ALDINGBOURNE PARISH COUNCIL

Re: AL/70/13 Application for the removal of Condition 7 (land restored to former condition) following a grant of planning permission AL/119/10/.

Site: Nyton Stables, Nyton Road, Aldingbourne	Client: Mr J Cole	Scale: AS SHOWN	
Drawing Title: Landscape Details - Additional Information	Drawing No: CTP/5153/LAND(R3)	Drawn By: IM/0710

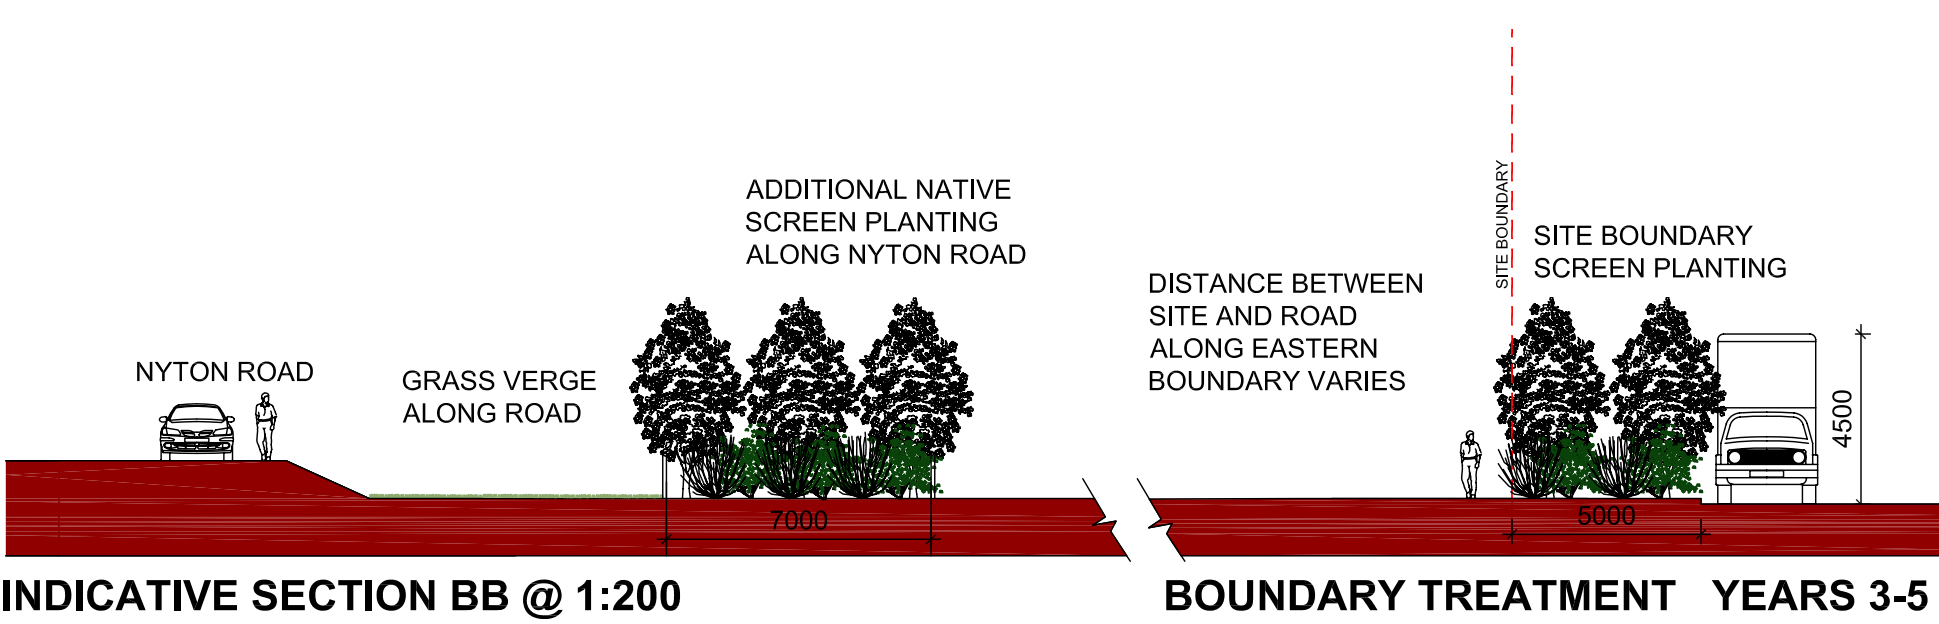
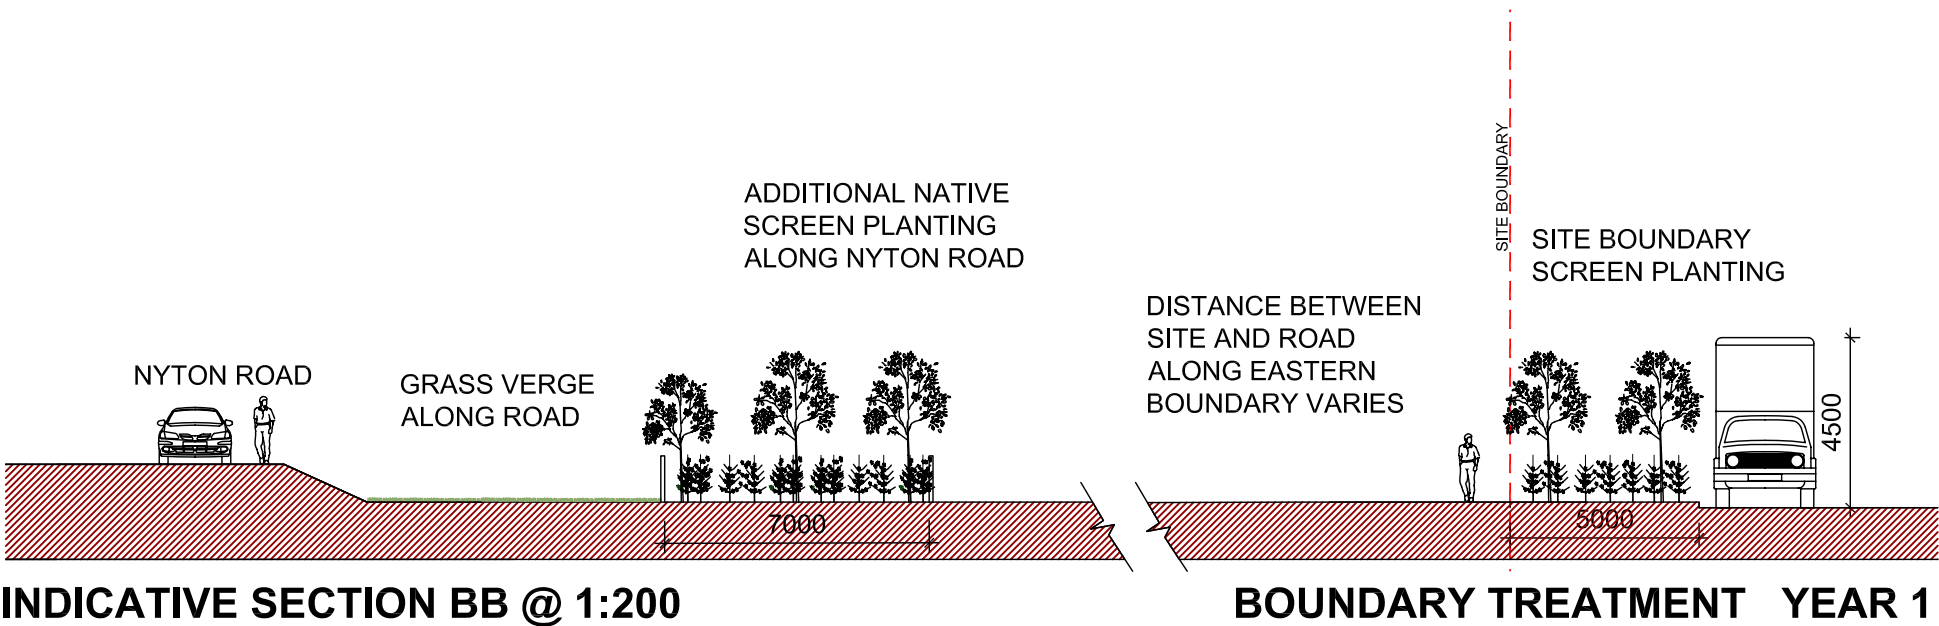
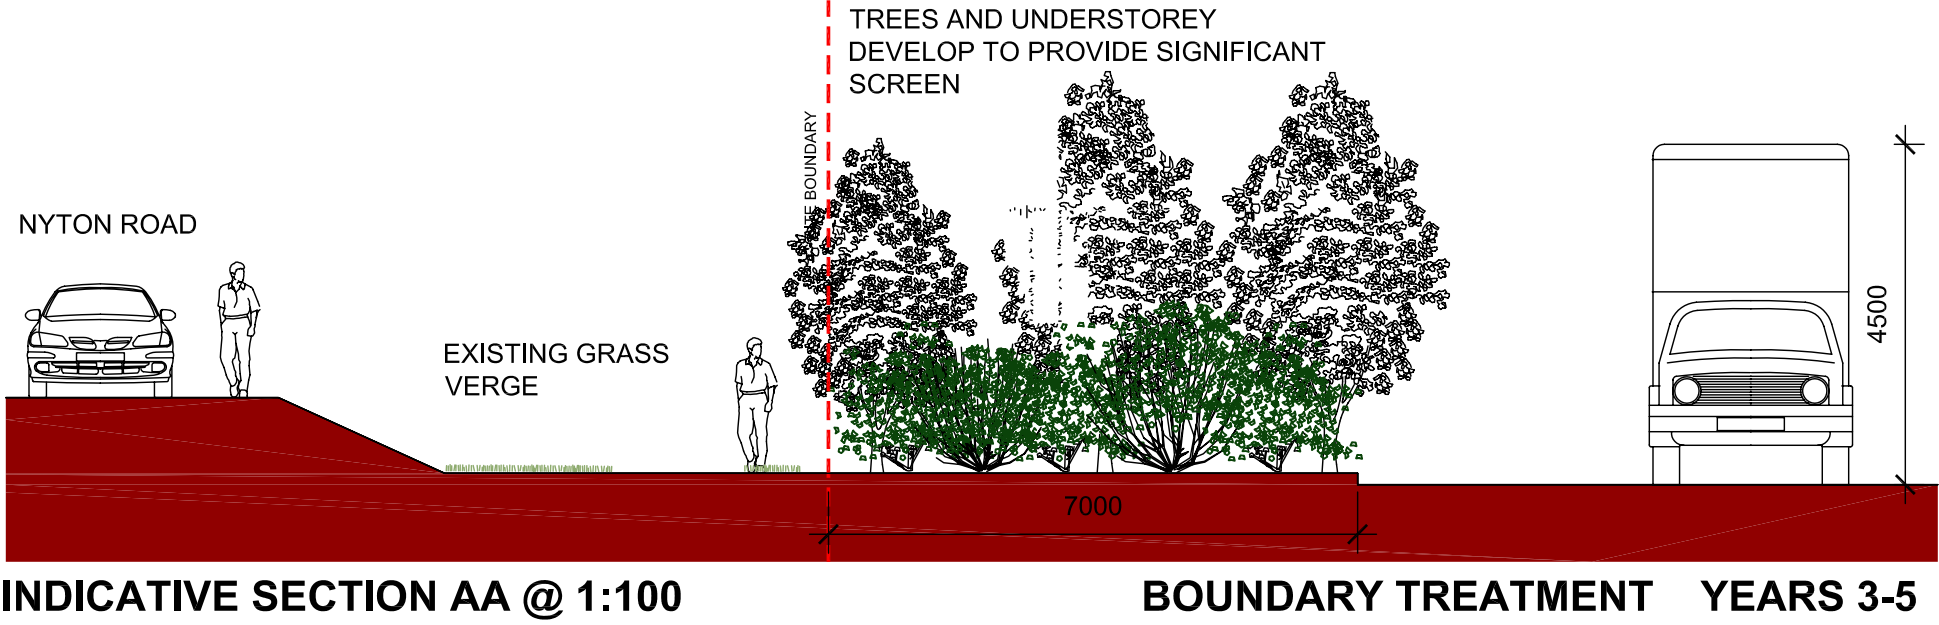
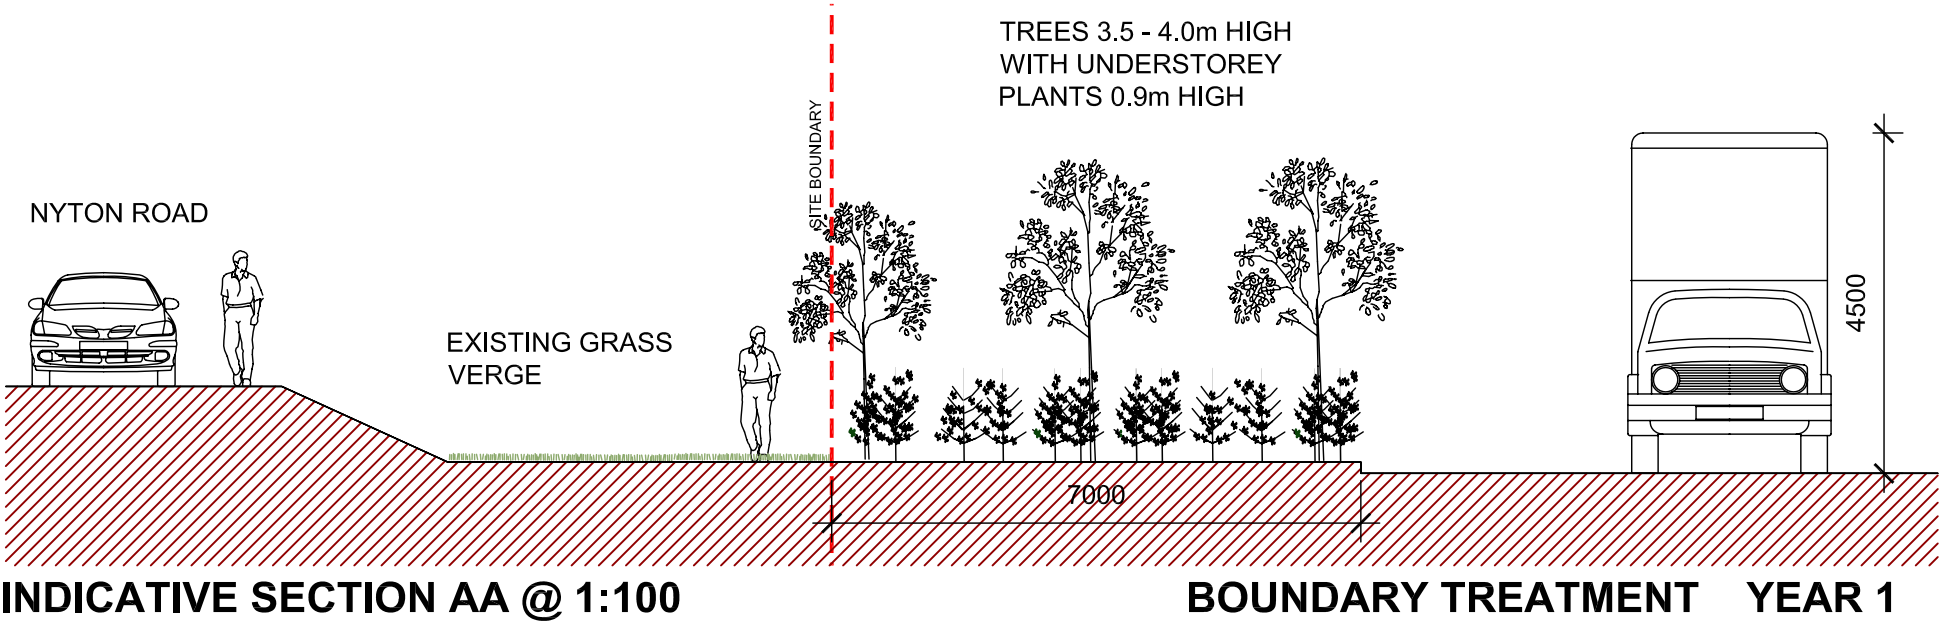
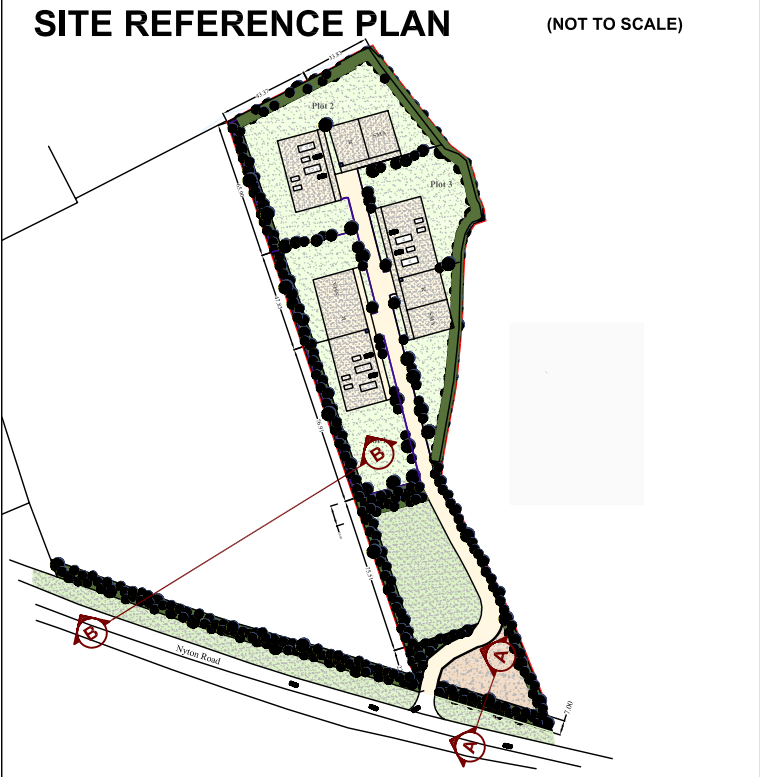
The Parish Council also wish to draw attention to the Landscape Proposals Plan submitted with application AL/70/13. The plan as submitted clearly shows the planted landscape bund extending eastward to the boundary of Aldingbourne Nurseries. This is the same plan as submitted under AL/119/10. The landscape bund as implemented under AL/119/10 does not fully extend to the boundary of Aldingbourne Nurseries and consequently views are afforded to the high sided vehicles and showground equipment currently parked on the Travelling Showpersons site, which adversely affect the visual amenity of the locality and appear visually obtrusive and harmful to the rural character and appearance of the open countryside in contradiction to saved Policy GEN 3.

It documented in the officers report AL/119/10 that the impact to "visual amenities of this rural area is considered to be, initially, unacceptable." The implementation of the landscape scheme as submitted was an important material consideration to the determination of the planning application.

It is therefore considered that the implementation of the **full** landscape scheme as submitted under AL/119/10 and AL/70/13 **must** be adhered to (without revision) in the determination of the application as submitted or any temporary extension of the extant permission.
